**WELWYN HATFIELD COUNCIL – DEVELOPMENT CONTROL**  
**DELEGATED REPORT**

<b>APPLICATION No:</b>	<b>N6/2009/1211/FP</b>
------------------------	------------------------

**Proposed Layout**  
Scale 1:50

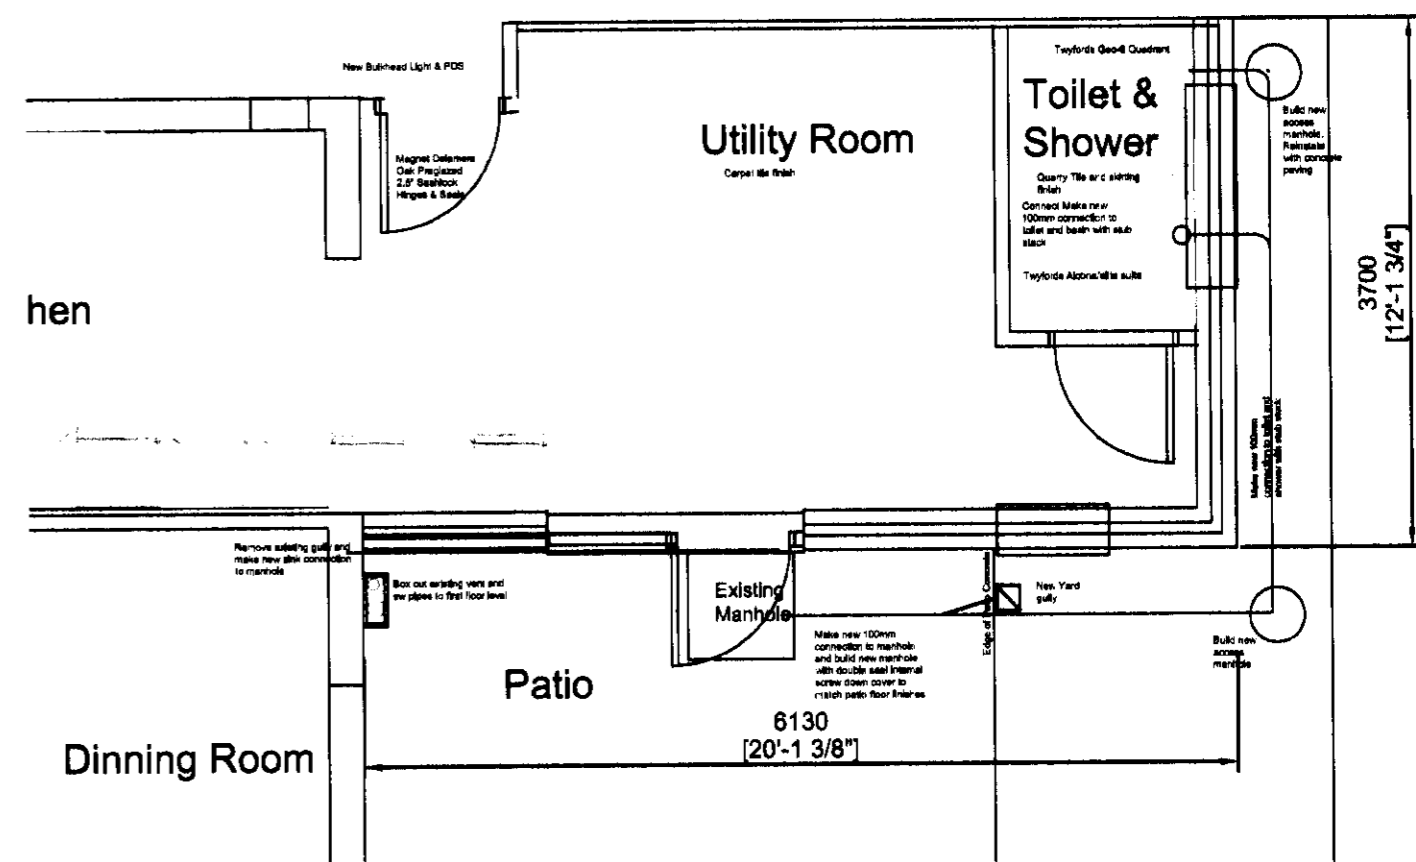
The application property has an existing single storey rear outhouse. The proposed development incorporates an extension to this existing development and would increase its overall width and alter its design and appearance. In this instance it is considered that the positioning of the extension at the rear of the dwelling would restrict the views of the extension from the frontage of the street scene, which would minimise its impact on the street frontage.

The proposed extension, by virtue of its small scale, appropriate design and width which does not extend across the full width of the dwelling, is considered would be in-keeping with the character and appearance of the application site and the surrounding area and would not detract from the architectural and visual interests of the existing property. It is considered that the proposed development would not have an unreasonable cumulative impact on the character and appearance of the existing dwelling, and would therefore not represent the over-development of the existing dwelling and would remain visually subordinate to the original property.

**Proposed Roof Layout**  
Scale 1:50

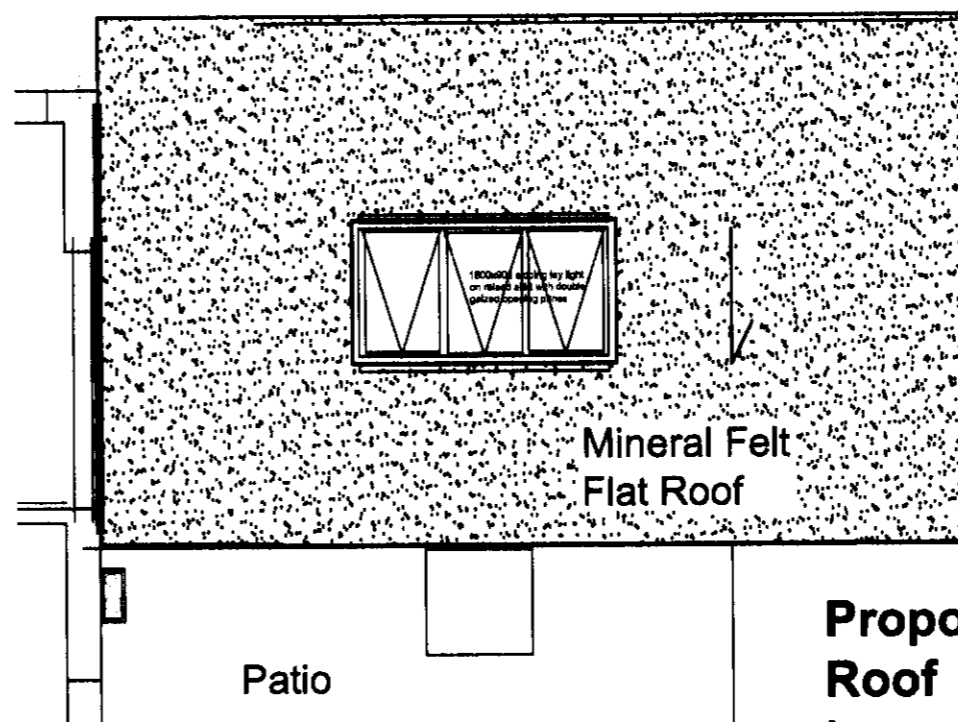
In terms of its detailed design, the existing single storey rear structure would be altered to have a flat roof together with the proposed extension. Rear extensions in

the Garden City characteristically feature flat roofs. Therefore, as a result of the design of the extension, it is considered that the extension would be characteristic of extensions in the Garden City. Furthermore, the brickwork to be used in the construction of the development would match the existing brickwork. Whilst the window detailing of the extension would not match the existing detailing of the windows, it is considered that an appropriate condition could be attached to any permission which may be given, which would ensure that the windows were of a similar design and appearance to the existing dwelling. As such, it is considered that the proposed extension would not have an adverse impact on the character and appearance of the building.

**Proposed Side Elevation**  
Scale 1:50

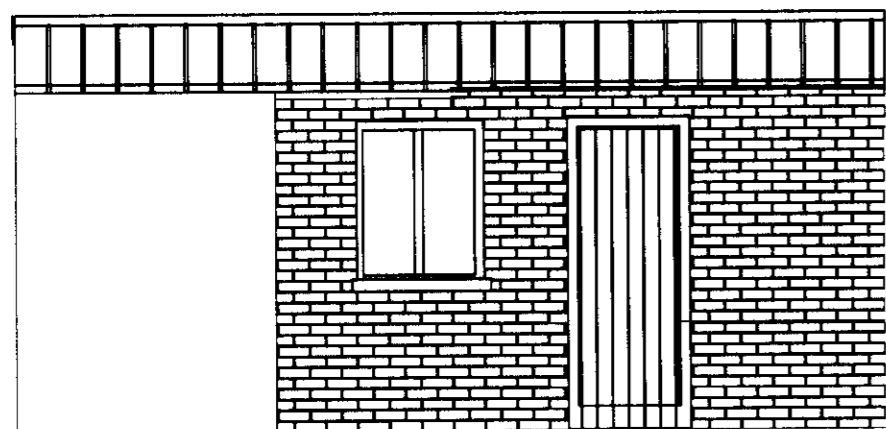
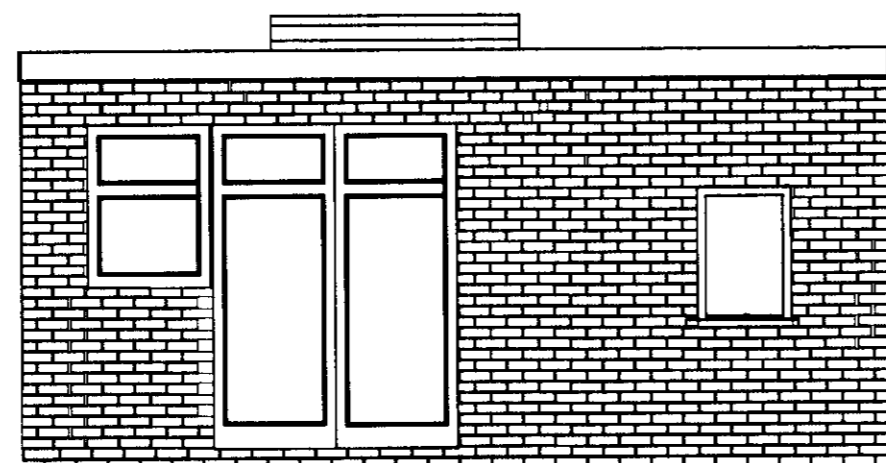
In terms of privacy, windows would be inserted into the side elevation of the development which would look towards No. 191. However these windows would be at ground level where there is an existing 1.8 metre high boundary fence along the common boundary with No. 191 and No. 189. As such, it is considered that the proposed development would not result in any undue loss of privacy to the occupiers of this property.
